A38 Derby Junctions NSIP

ExA's First Questions for deadline 1 on 5th November

Historic England Response

Drawing Title  
FIGURE 2.7  
LITTLE EATON JUNCTION  
GENERAL ARRANGEMENT

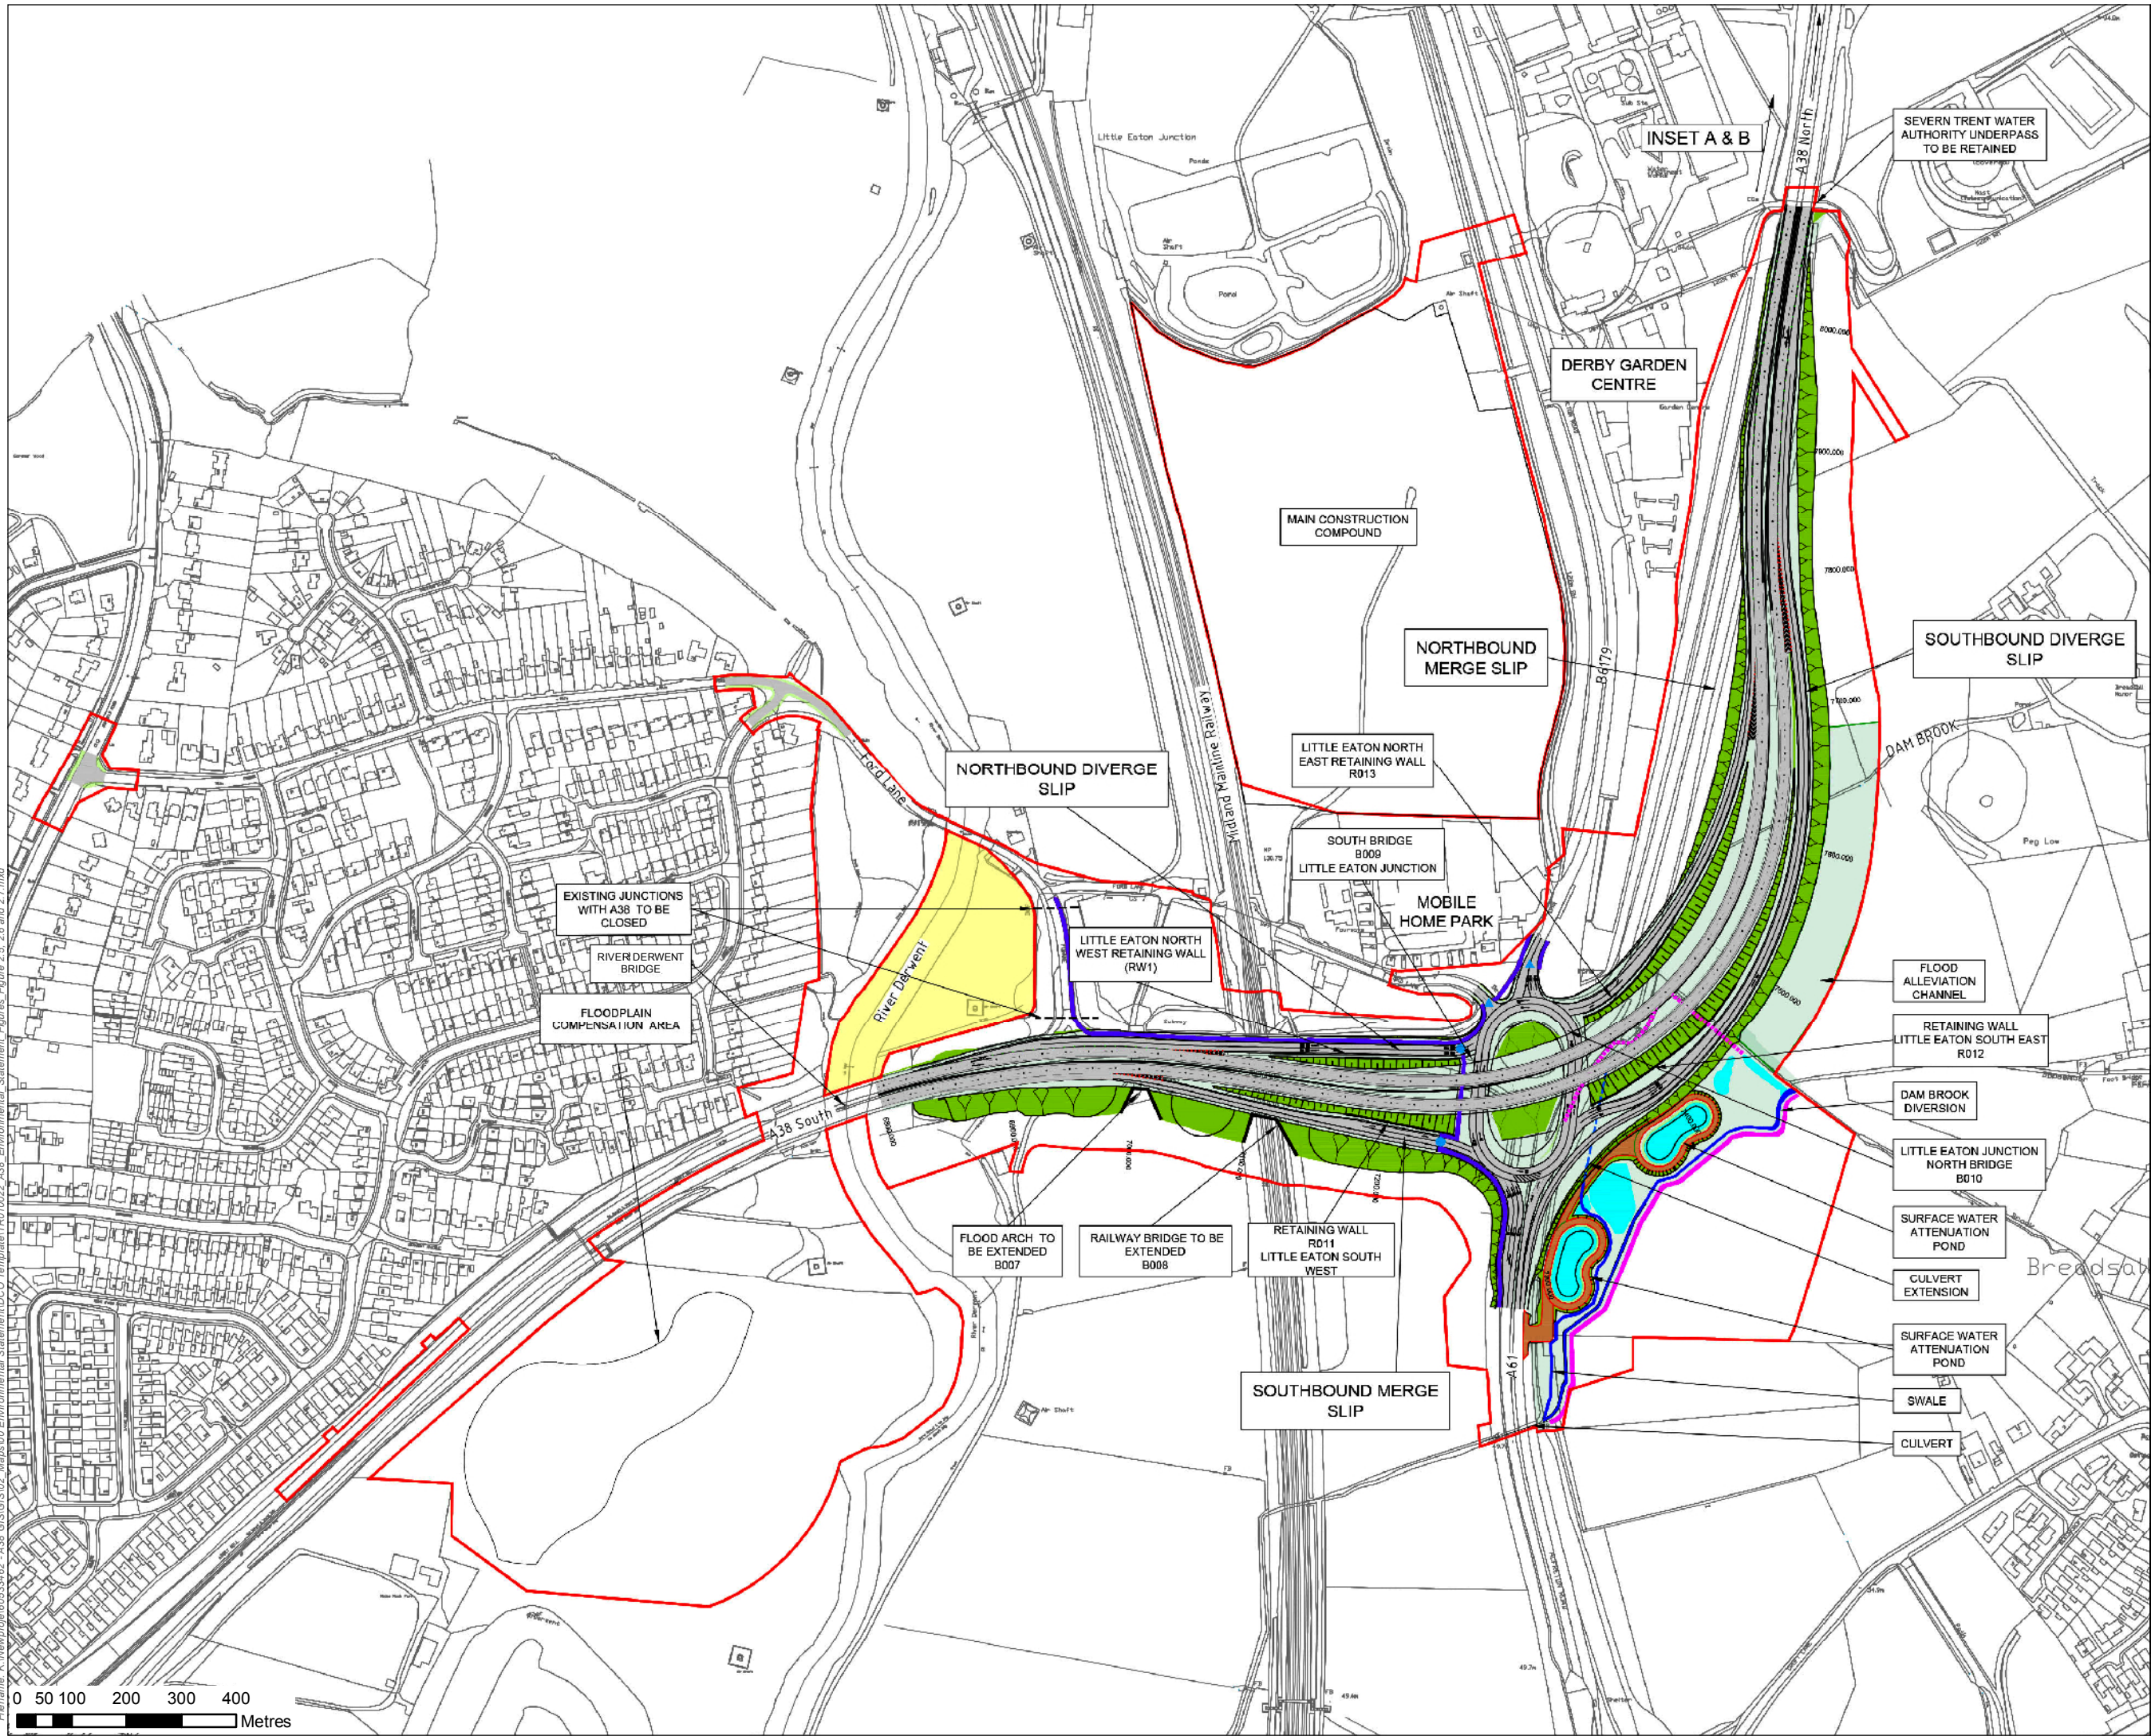
11.8	<p>ES Chapter 6 [APP-044],</p>	<p>ES paragraphs 6.15.33 and 6.15.34 summarise the effects of the proposal on the settings Breadsall Conservation and the Church of All Saints. Are you content that the effects of the embankment in terms of its height and siting, associated slip road and signage and the lighting at the junction</p>	<p>Yes.</p>

Little Eaton junction have been adequately considered?	
--	--	--	--
